ASSESSMENT REPORT

MIXED USE DEVELOPMENT, EASTLAKES SHOPPING CENTRE MP 09_0146 MOD 3

PLANTING PLAN - PUBLIC DOMAIN

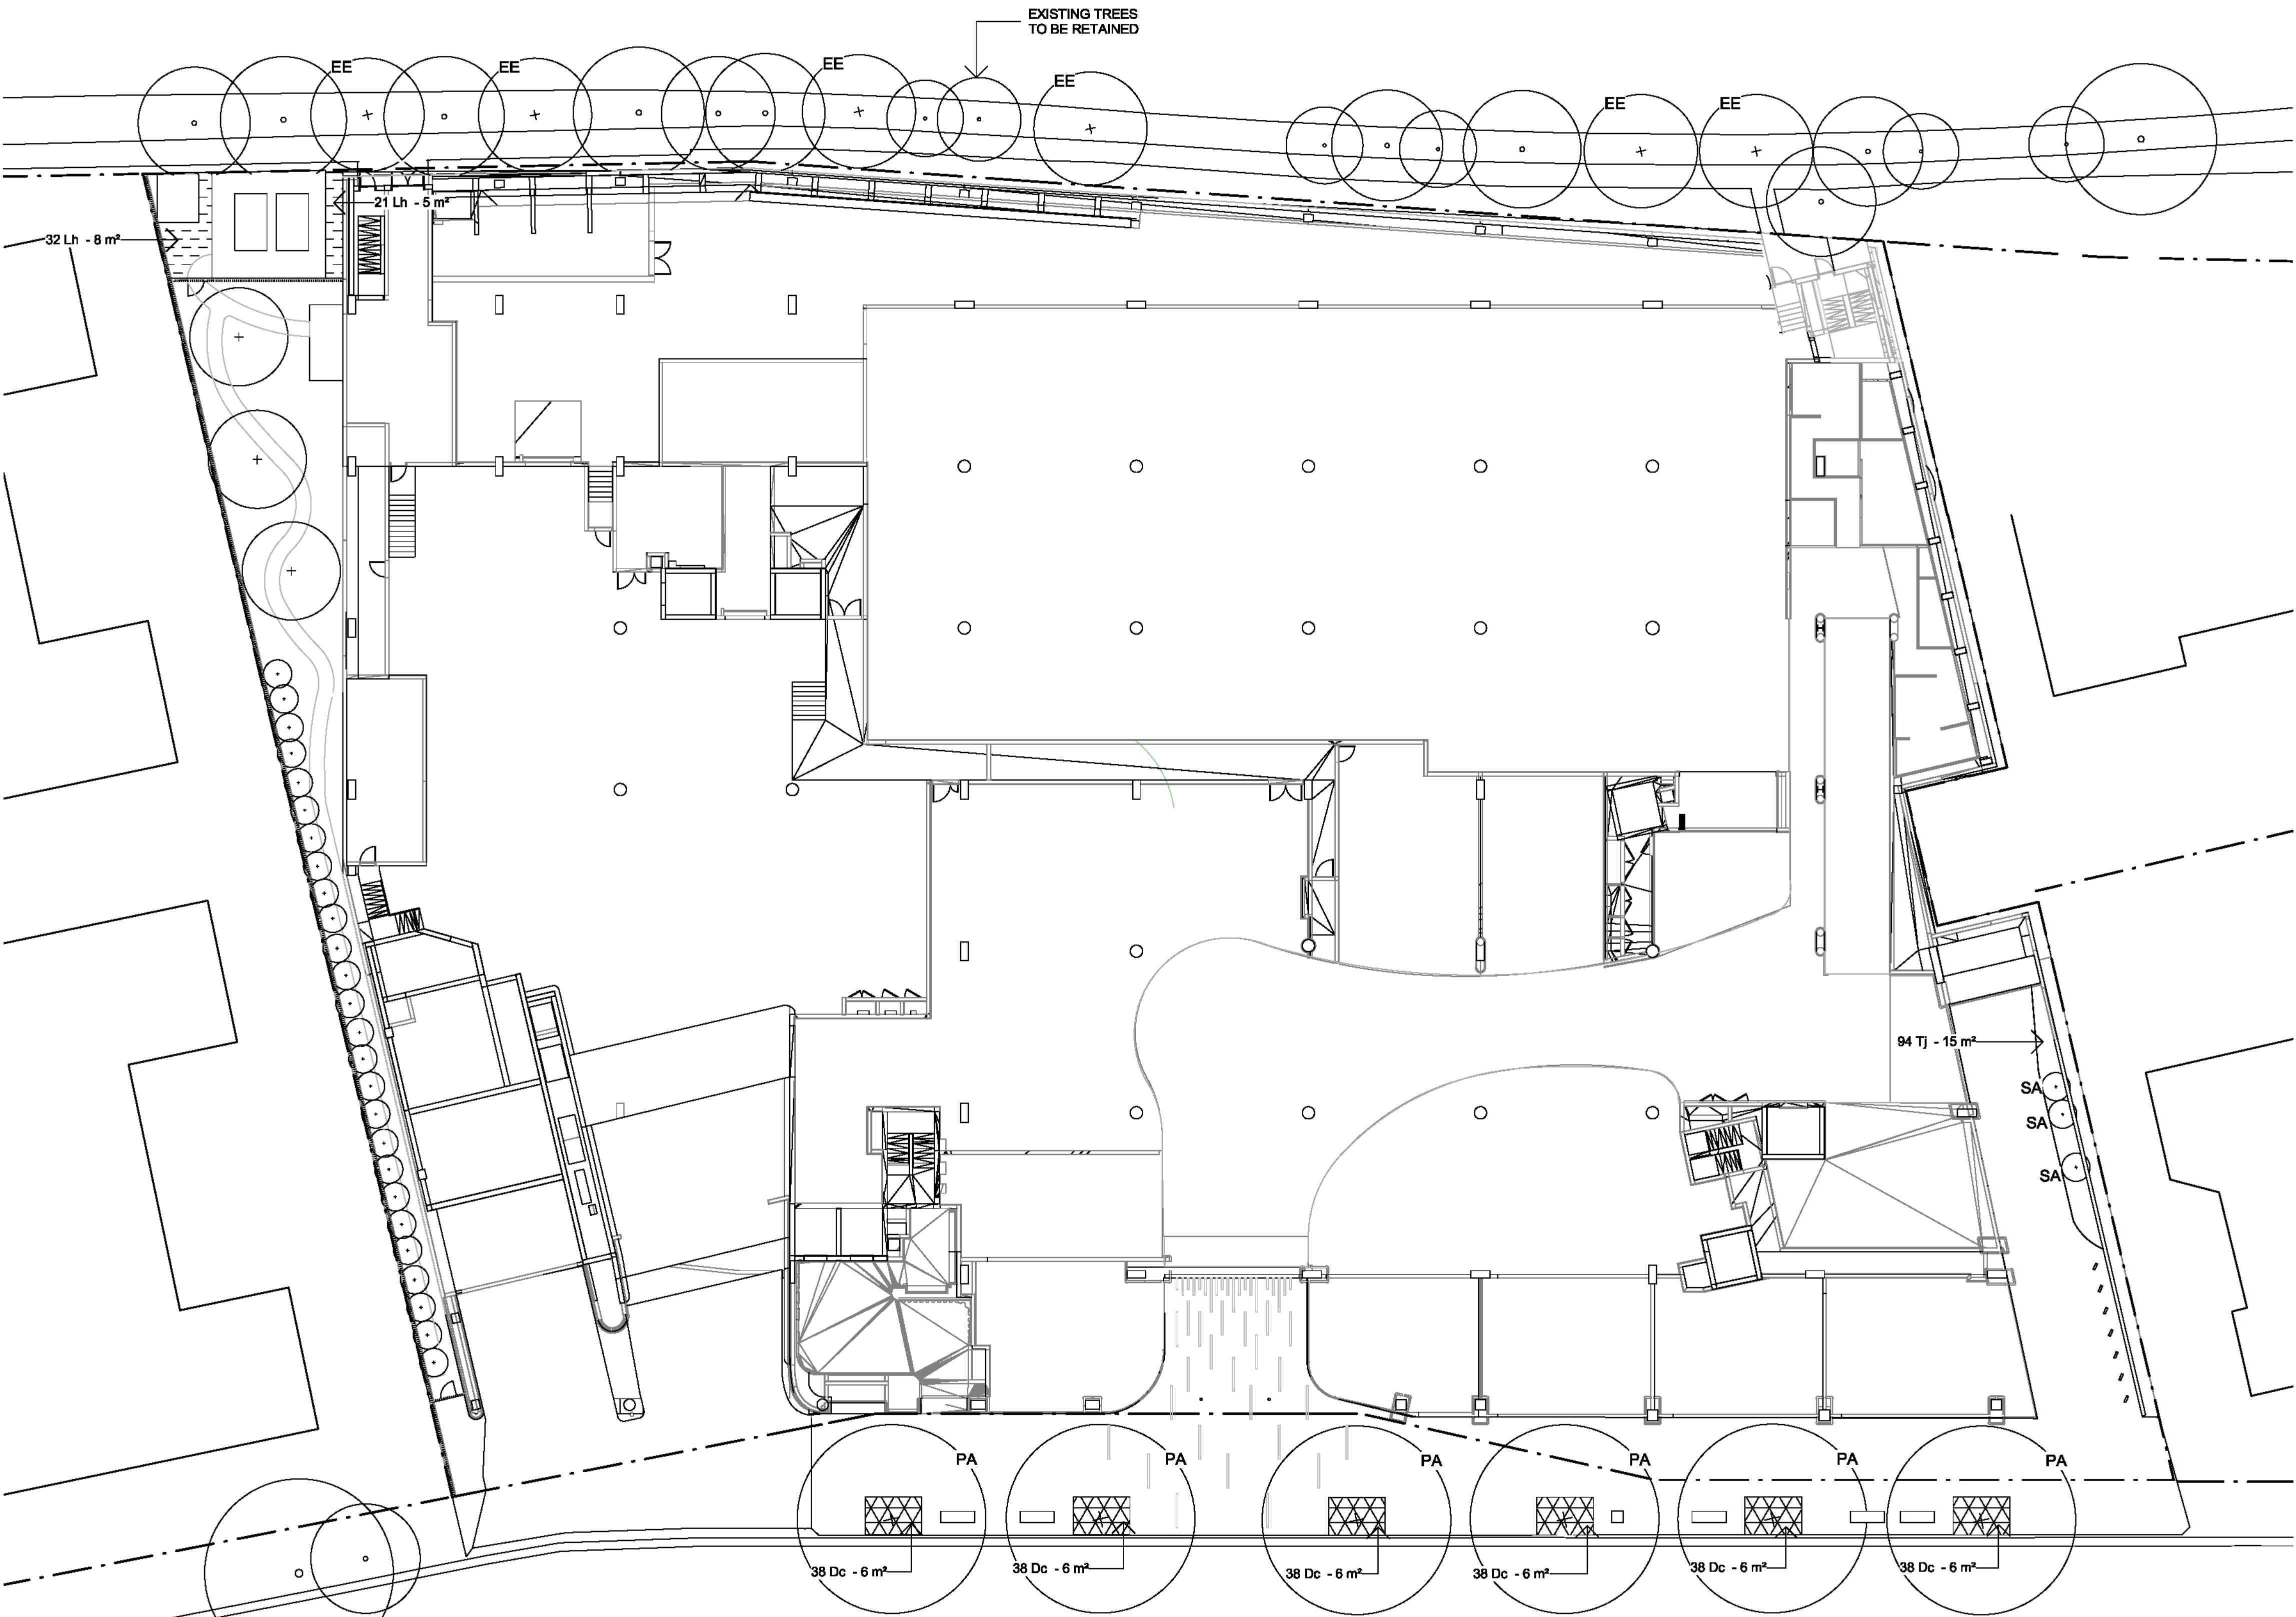
Council reviewed the updated diagram and advised it supports the proposed removal of the four London Plane Trees on the northern side of Evans Avenue. However, it recommended the replacement species by provided in accordance with the City of Botany Bay Street Tree Master Plan 2014, with the Applicant's Landscape Architect to make the final decision. It also requested that Council's Landscape Architect and Public Domain Engineer be invited to conduct and inspection prior to installation of the street trees.

The Proposal seeks approval to remove four existing street trees and replace them with six new street trees. The Proponent seeks approval to remove the trees because they would be impacted upon by the awning line of the approved building. The existing street trees would also be impacted upon by the underground services required by Condition B41 of the approval.

The Department has also recommended Council's suggested conditions requiring the Proponent to plant either London Plan Trees or Spotted Gum Trees (in accordance with the City of Botany Bay Street Tree Master Plan 2014) and Council officers to inspect the site before the street trees are planted. Subject to the recommended conditions, the Department is satisfied the proposal is acceptable.

3 EVANS AVENUE SECTION
1 : 50

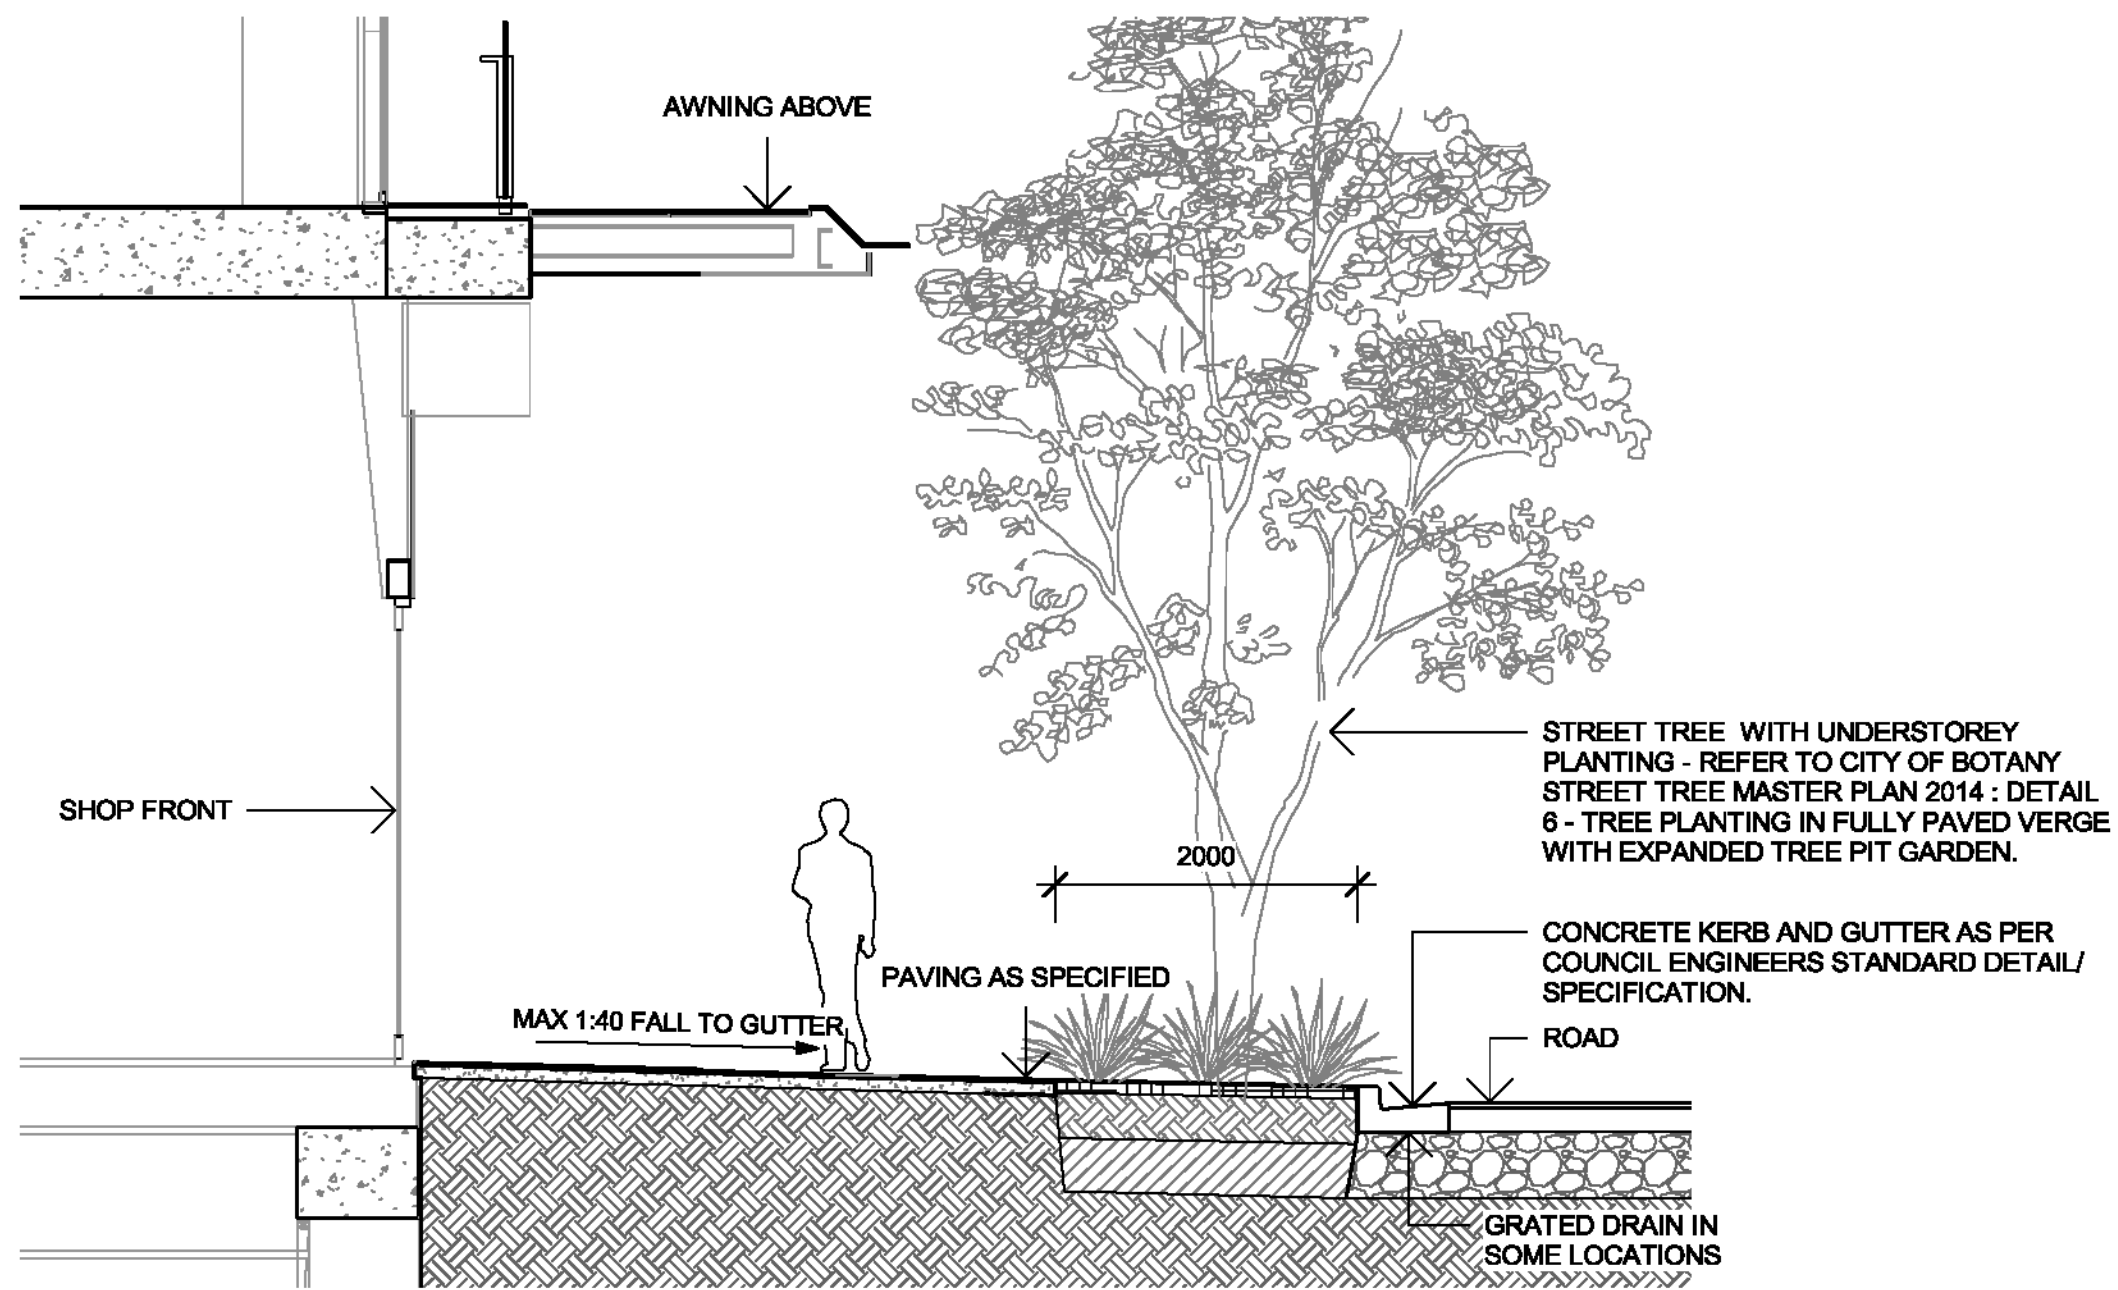
Council requested confirmation that the most updated Landscape Plans had been provided, and a section diagram for the awnings along Evans Avenue.

In response to Council's comments, the Proponent provided a section diagram for the awning along Evans Avenue and confirmed the submitted Landscape Plans are up to date.
